Single storey front extension, side extension, conversion of garage to habitable use and conversion of roofspace to habitable use to include a rear dormer and 3 front rooflights.

22 Singleton Crescent Ferring

Thank you for your internet representation made on 8th May 2019 which has been recorded as '**an objection**' with the comments as follows:

PROPOSED WEST
ELEVATION 1:100

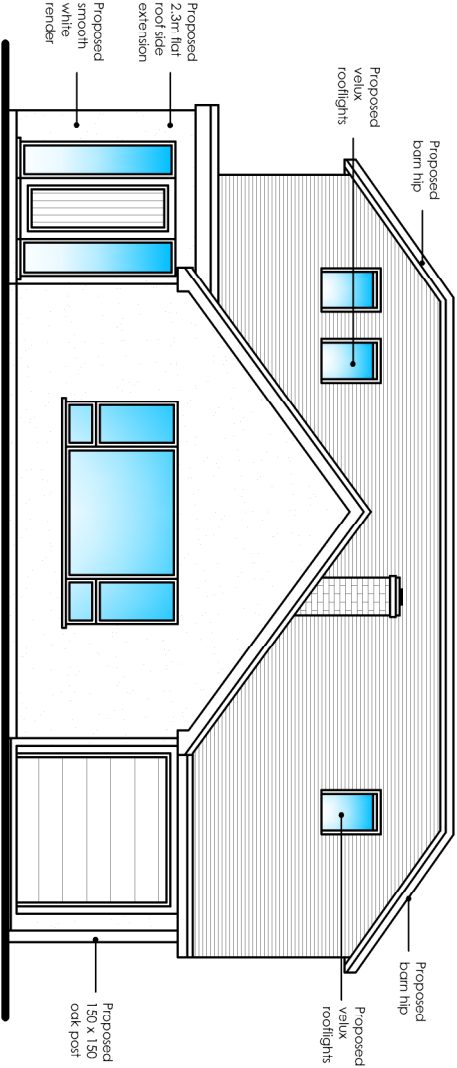
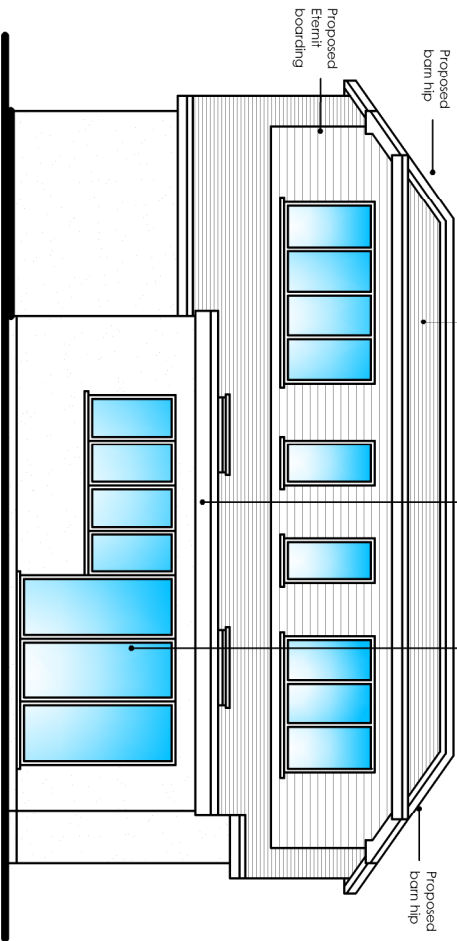
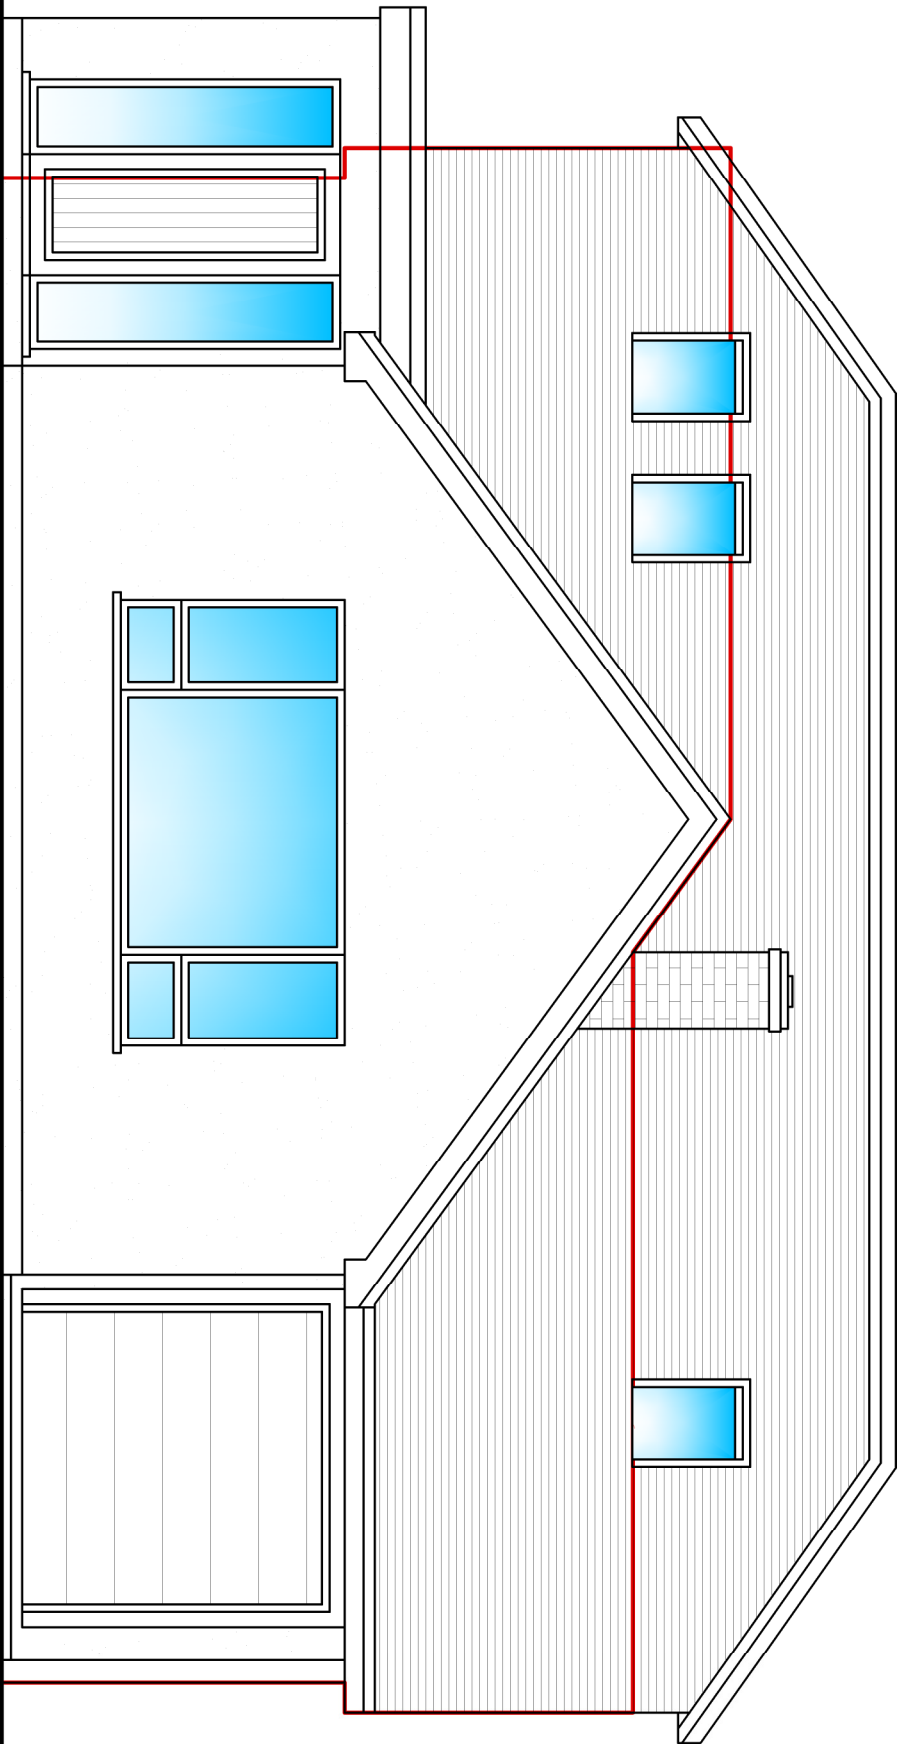
Ferring Parish Council object to this application as the application does not make an accurate representation of the surrounding setting of the site and the impact the proposed building would have on the street scene.

While a Planning Officer 'should' visit every application site, we would strongly recommend that such a visit definitely is made by the Planning Officer in this case to appraise the harmonious aspect of the existing properties in this location. Such a large development in such an open setting would clearly have a visually detrimental impact and dominate the street scene and adjacent properties.

PROPOSED ROOF PLAN 1:100

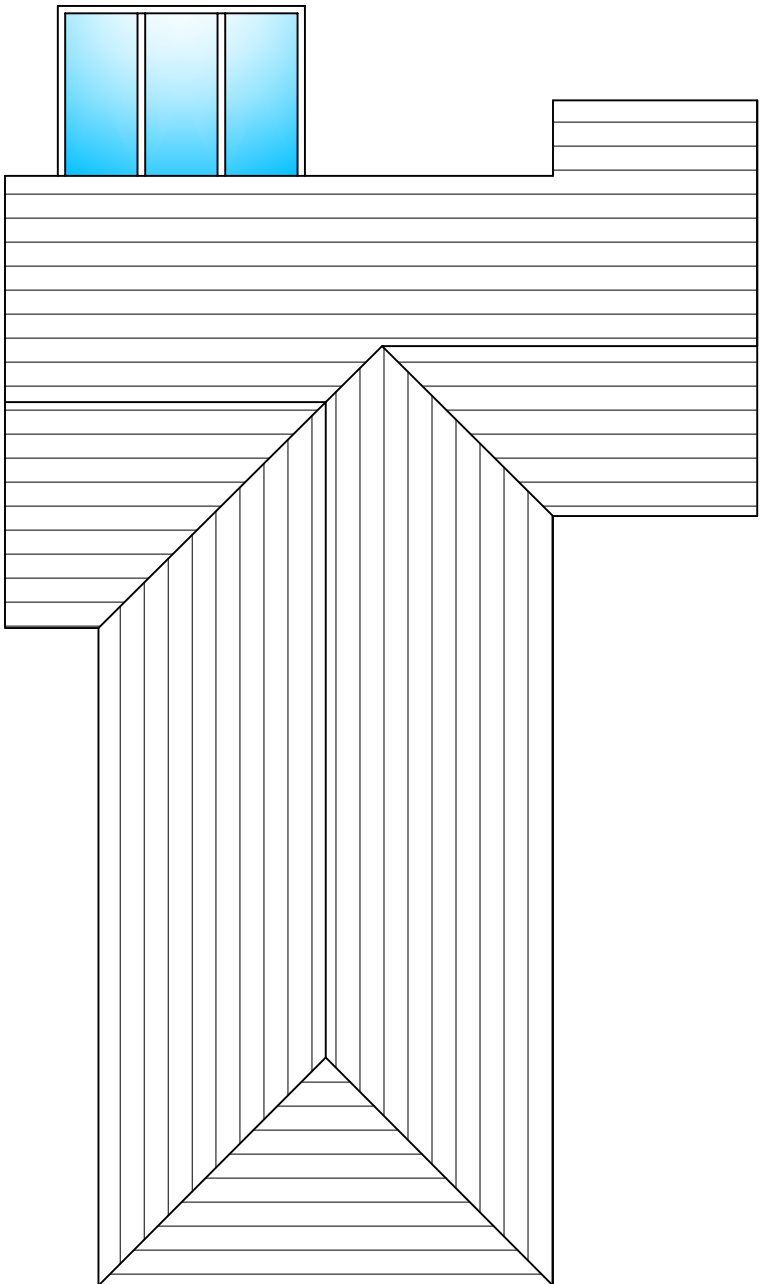
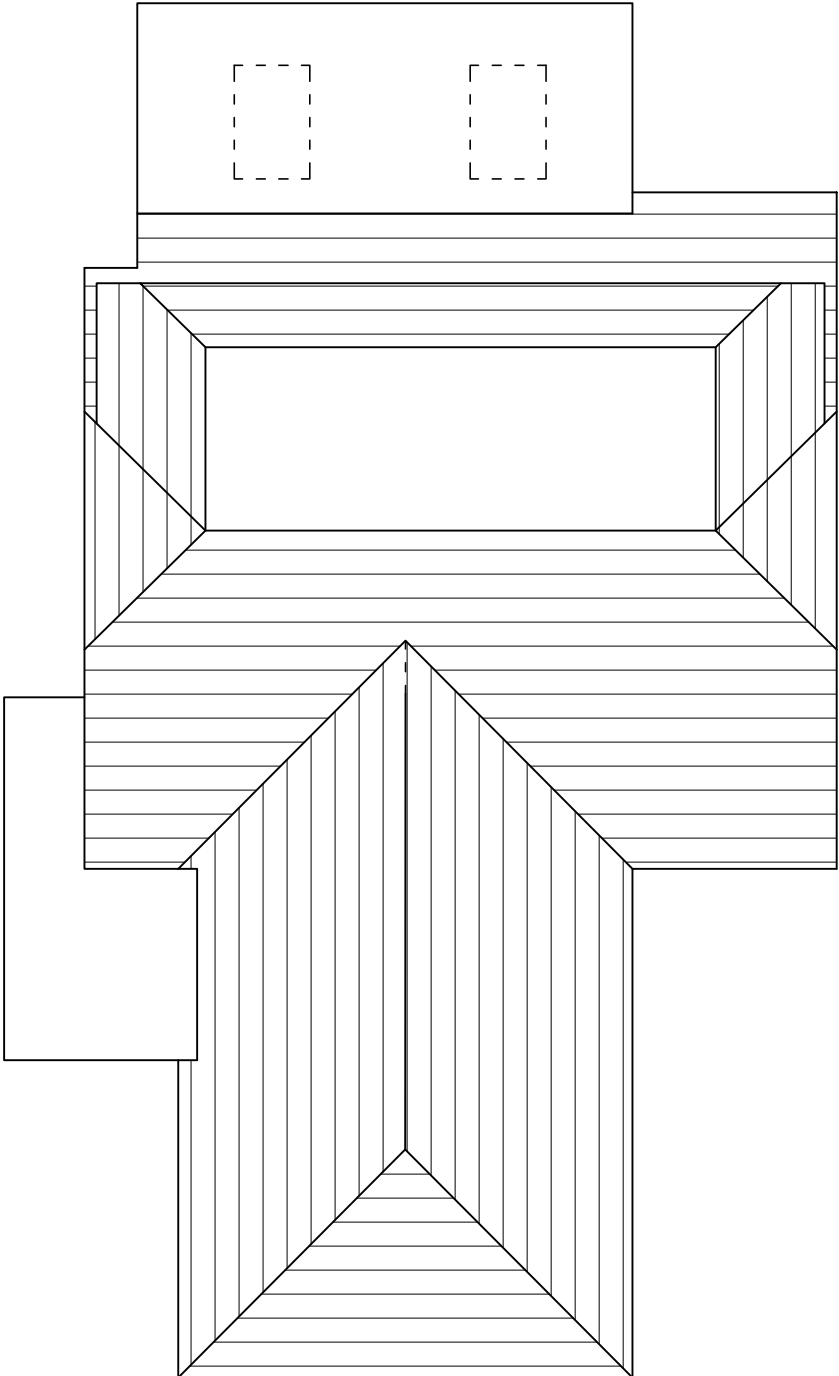
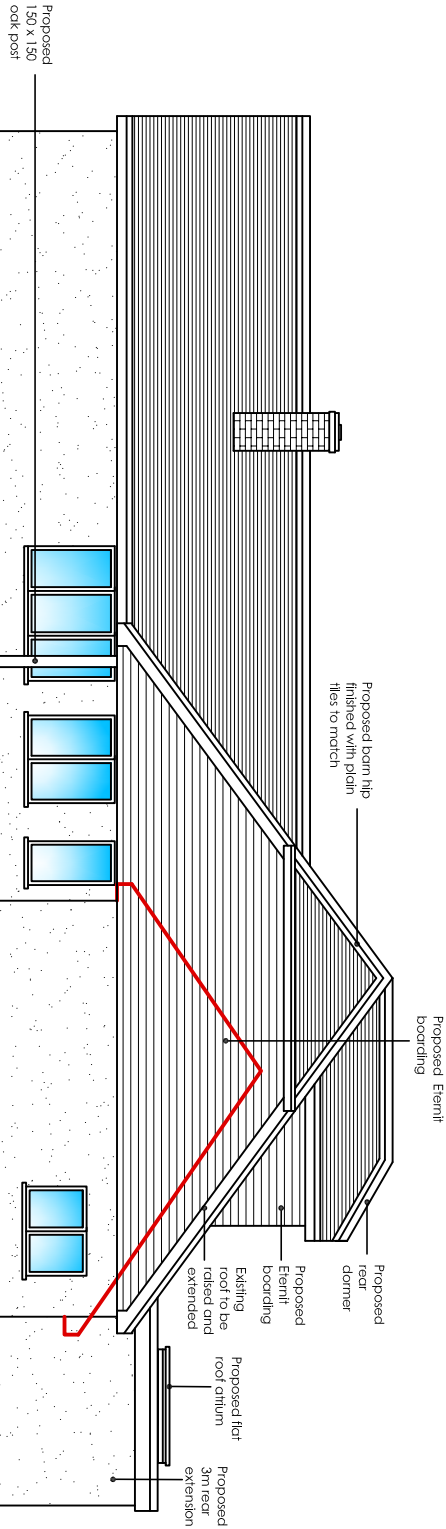
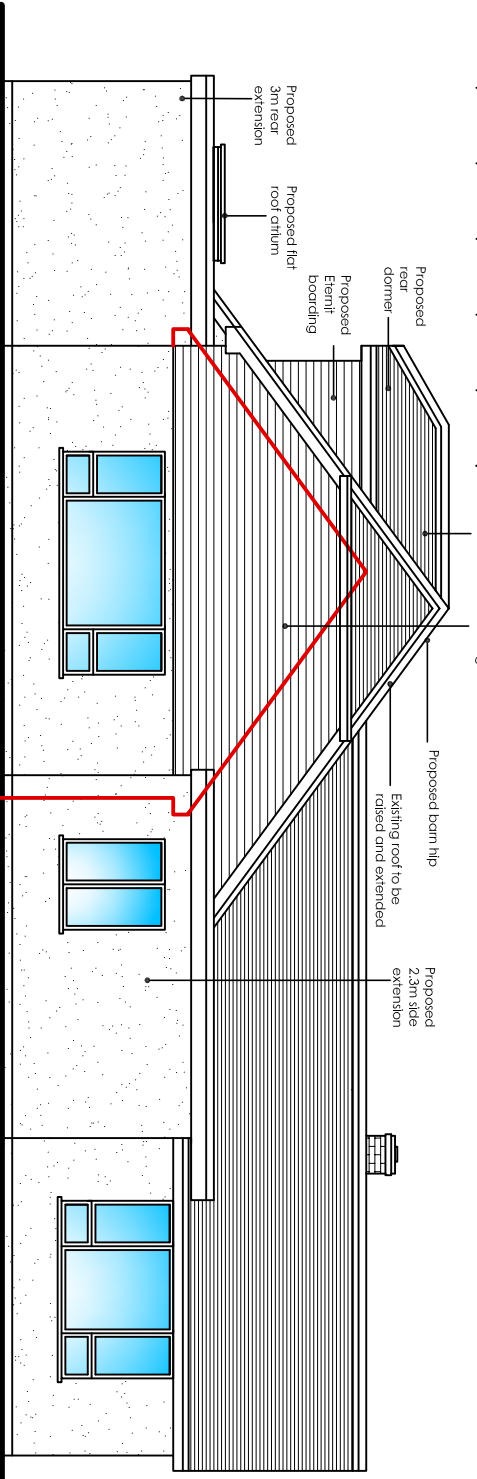
The scale of the proposed extensions would be out of keeping with adjacent properties as the mass cannot be considered subservient to the original dwelling and would constitute an over-development of the site. The proposed ridge height would dominate and be inappropriate on this plot and the type and scale of windows on the eastern elevation would deny neighbours the current level of privacy they have to enjoy the amenity value of their back gardens.
